From: Rhiannon Lloyd
Sent: 10 November 2025 14:42
To: Planning.Responses
Subject: FW: CM/37/25/HH ELMS PADDOCK - sub plan
Attachments: CND35_ SK01E.pdf

CM/37/25/HH

Please supersede Proposed Plans and Elevations SK01 ID 17.

Drawing **CND35_SK01** Rev **C**
Date **Jan 2025** Scale **1 : 50, 100@ A1**

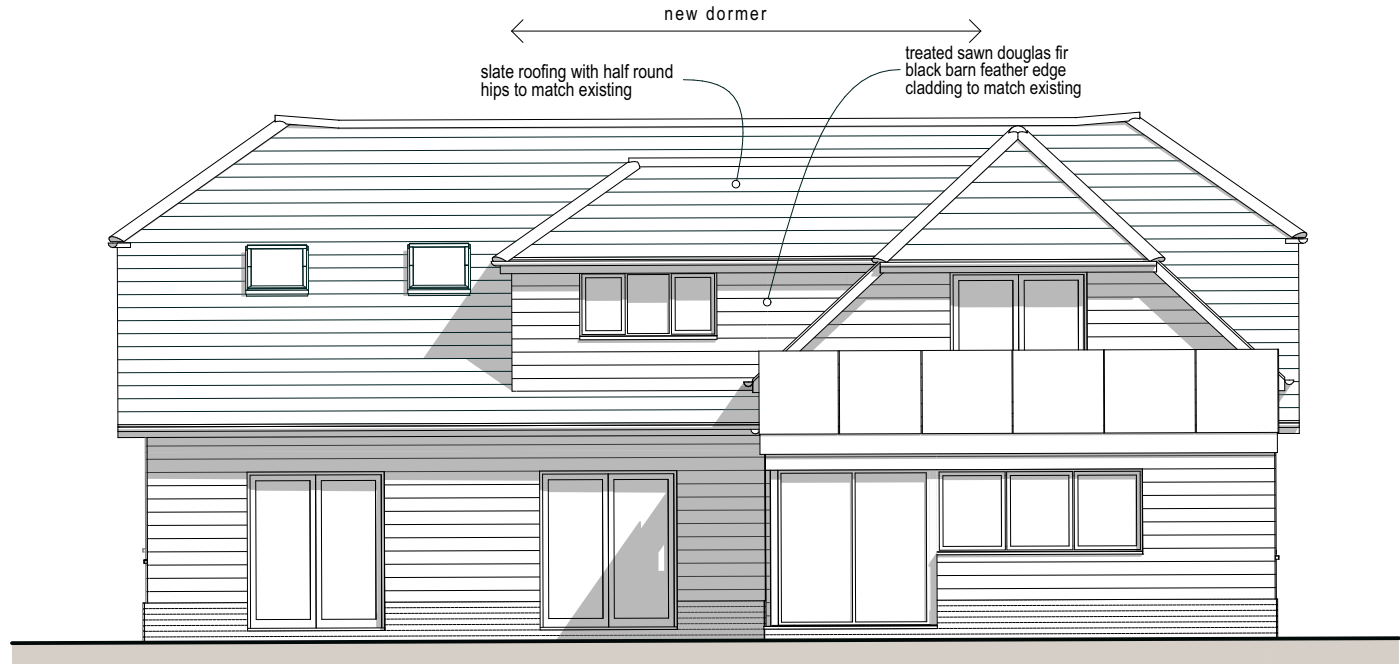
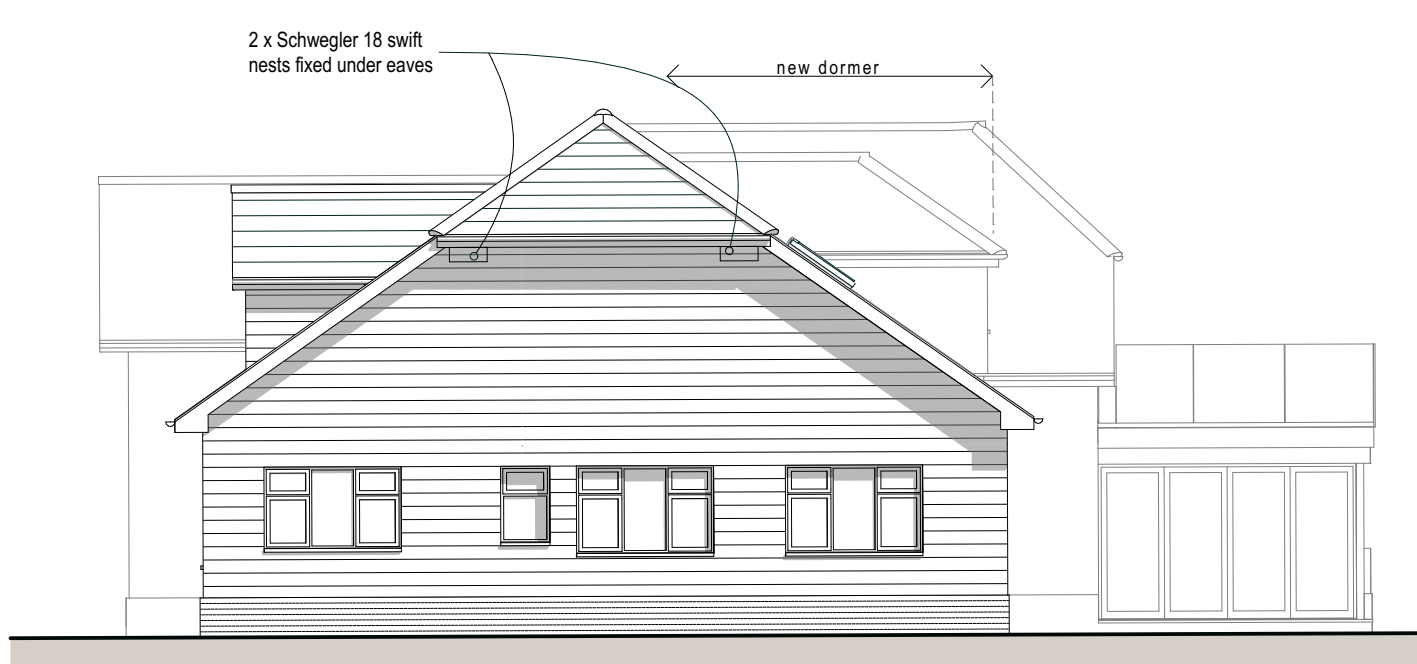
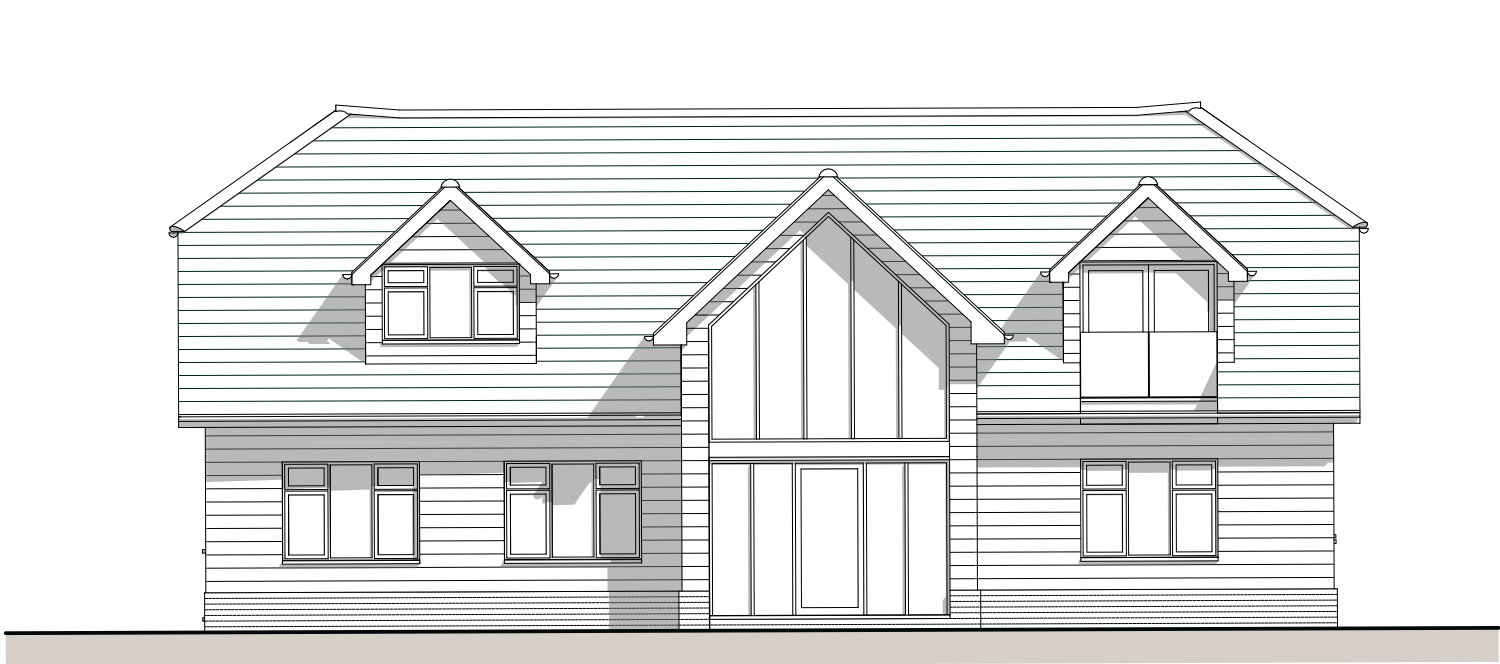
Thank you, however SK01 still shows 2 elevations labelled as the rear.

I notice that the proposed elevations are incorrect. The proposed elevations have the front (south) elevation labelled as the rear. Please could you provide an amended version at your earliest convenience.
